From: [REDACTED]
Sent: 12 August 2020 20:48
To: Zac Denton
Subject: FG/51/20/HH - 66 Elm Park, Ferring

With regard to the Rev D drawings the following errors are present.

PROJECT Groome, No.66	DRAWING NO. 1459-P301	SCALE 1:100 @ A3	18	B
ADDRESS No.66 The Cottage Elm Park Ferring BN12 5RW	DRAWING TITLE Proposed North & East Elevations	DRAWN BY CRE8TIVE LINES - ROZ NOWAK	June 2020

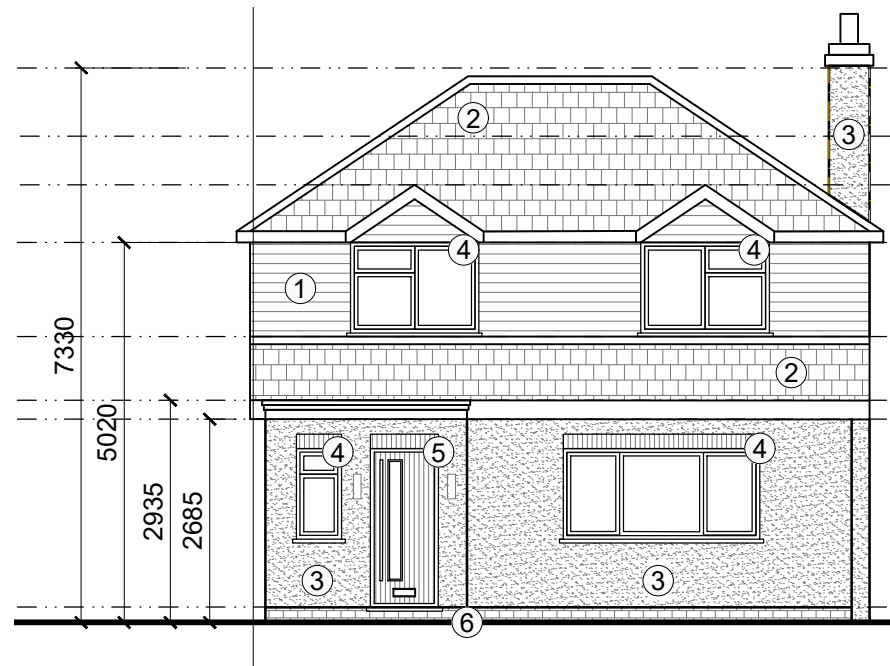
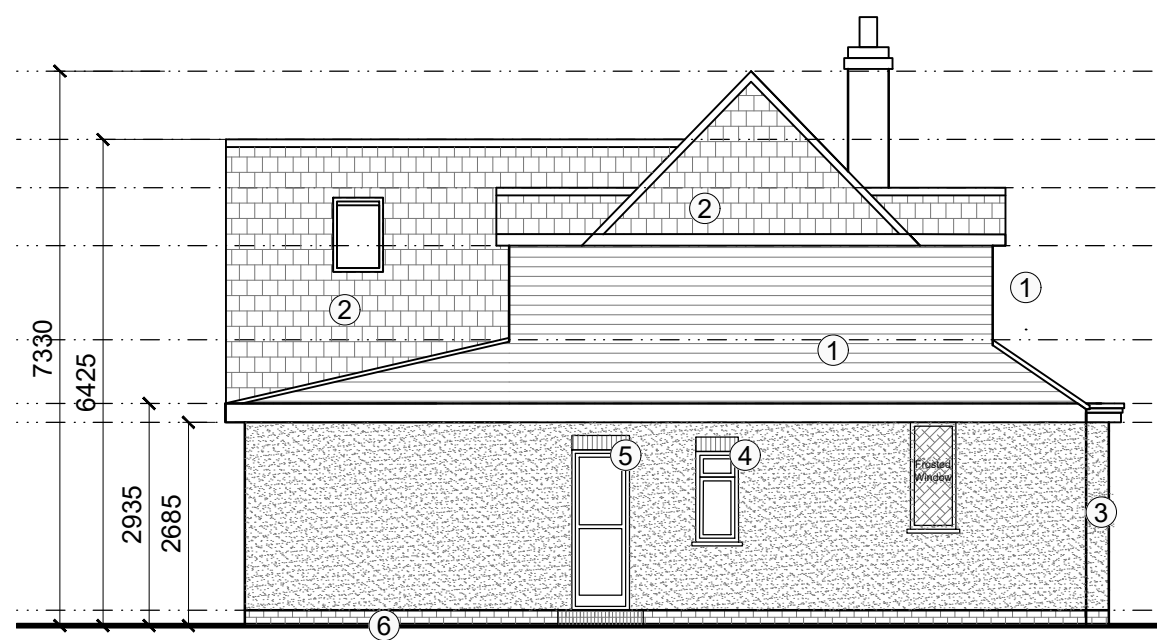
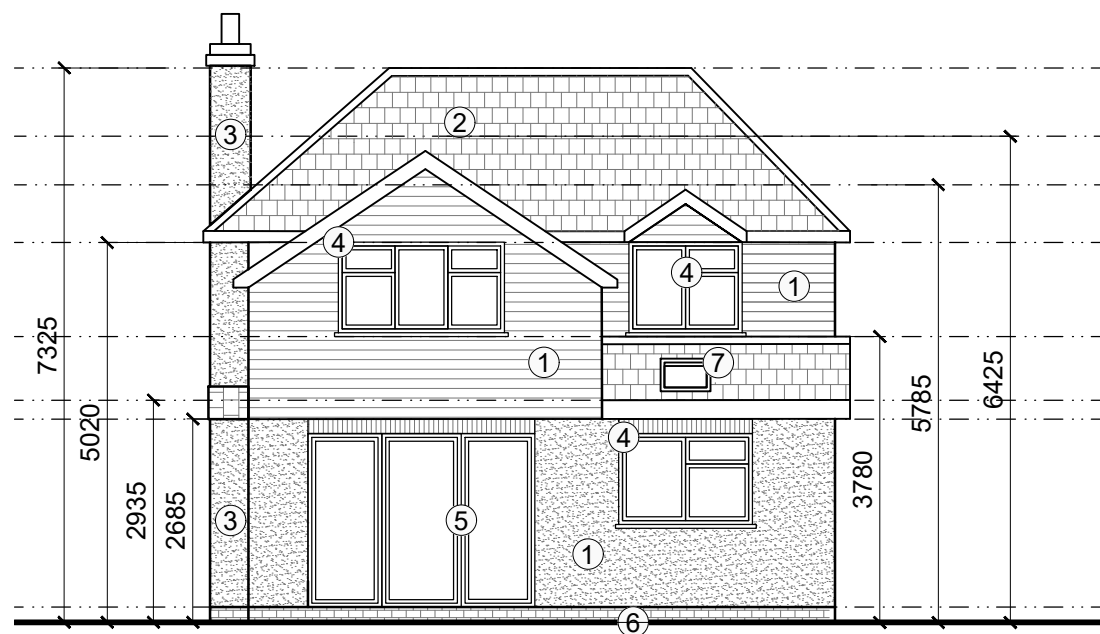
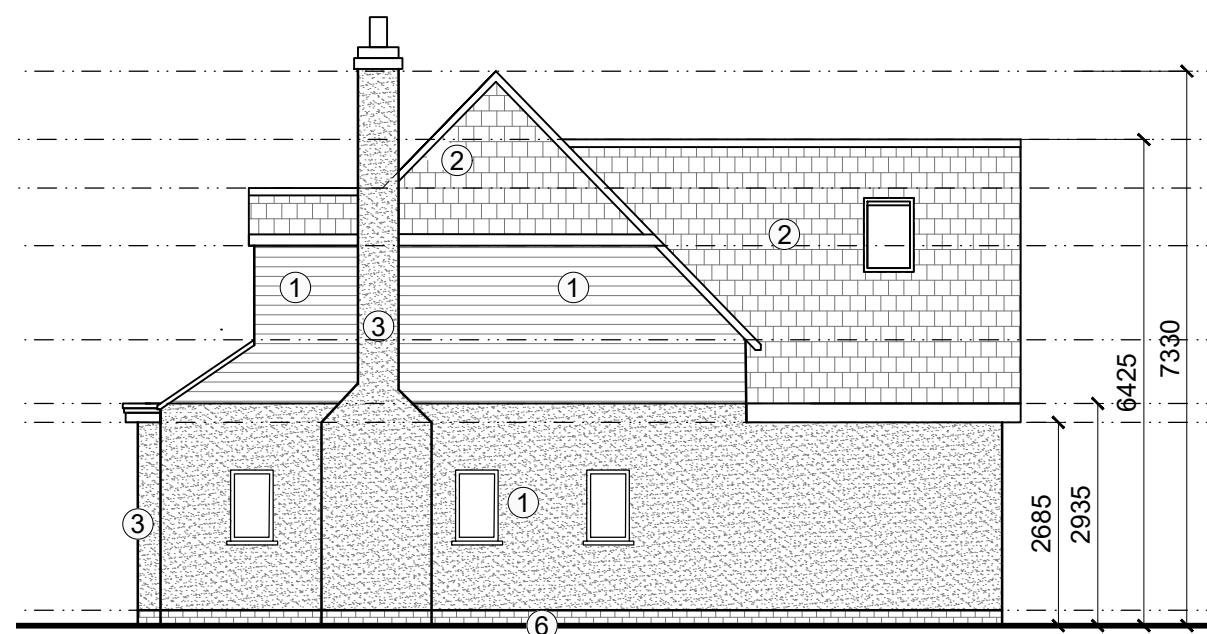
My previous comments regarding the full width dormers to the North and South elevations still stand.

1) The eaves length at the bottom of the hips on plan is different to the length on East and West elevations.

2) The width of the dormer flat roof is different on the plan/elevations. That may well be because of point 1.

Might I suggest that the negative aesthetic impact of the full width dormers could be tempered by setting the cheeks back approx.500mm from the gable face.This doesn't impact significantly on the upstairs rooms. As it stands the finish on the cheeks (tiled) is different from that on the gables (composite cladding) although they are flush?
